CITY OF ALBUQUERQUE

**Re: Hope Plaza Subdivision
Grading and Drainage Plan for Engineer Certification
Engineer's Stamp dated: 4-28-14 (C20D064)
Certification dated: 1-20-15**

GRADING & DRAINAGE PLAN

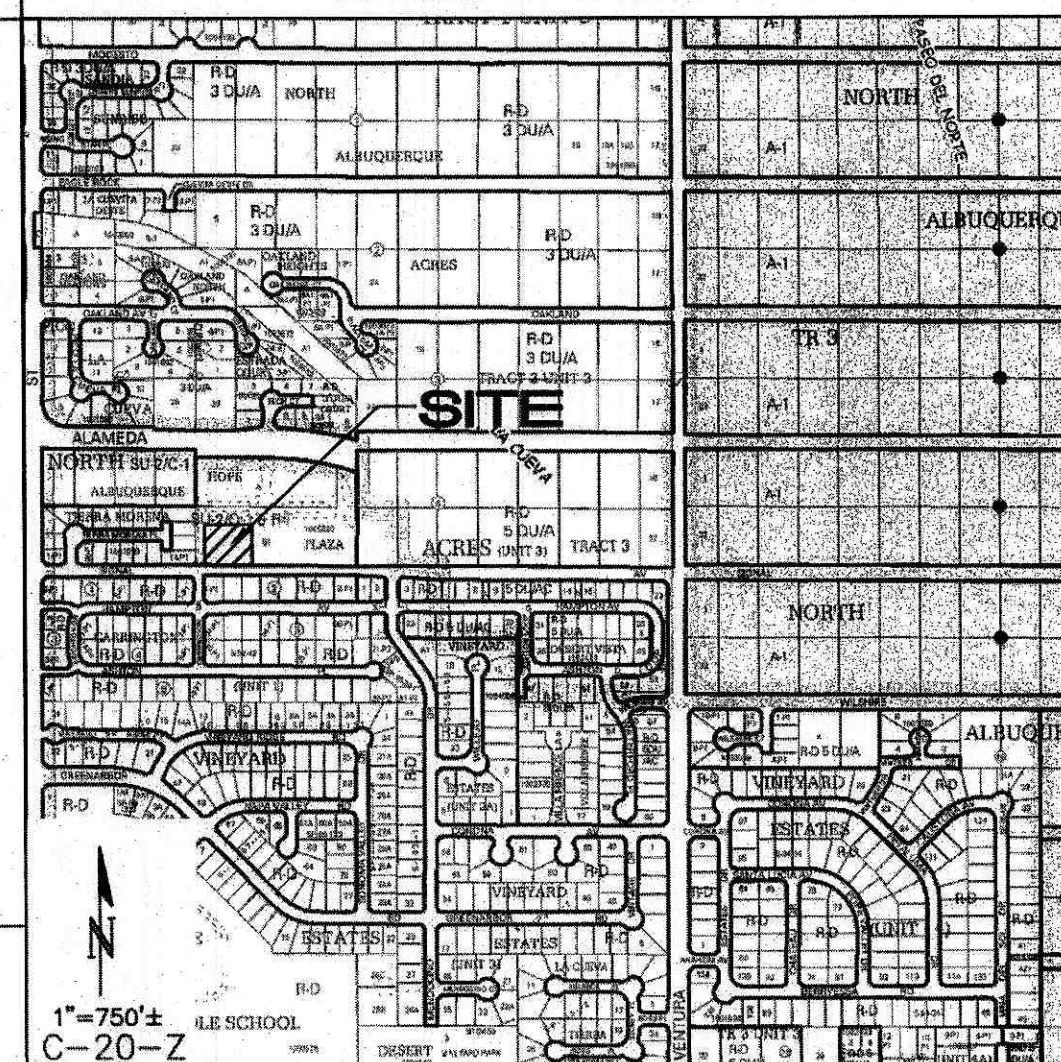
- The Work Order needs to be completed before going forward with this project.
- The sidewalk culvert to the north needs to be removed. Offsite flows were not accounted for when this project was accepted for grading permit.
- The sidewalk culvert needs to be accepted by Jason Rodriguez with DMD and the Hydrology department notified of this acceptance.
- The retaining walls need to be in place before acceptance.
- This site does not meet minimum requirements for substantial compliance of the drainage ordinance.
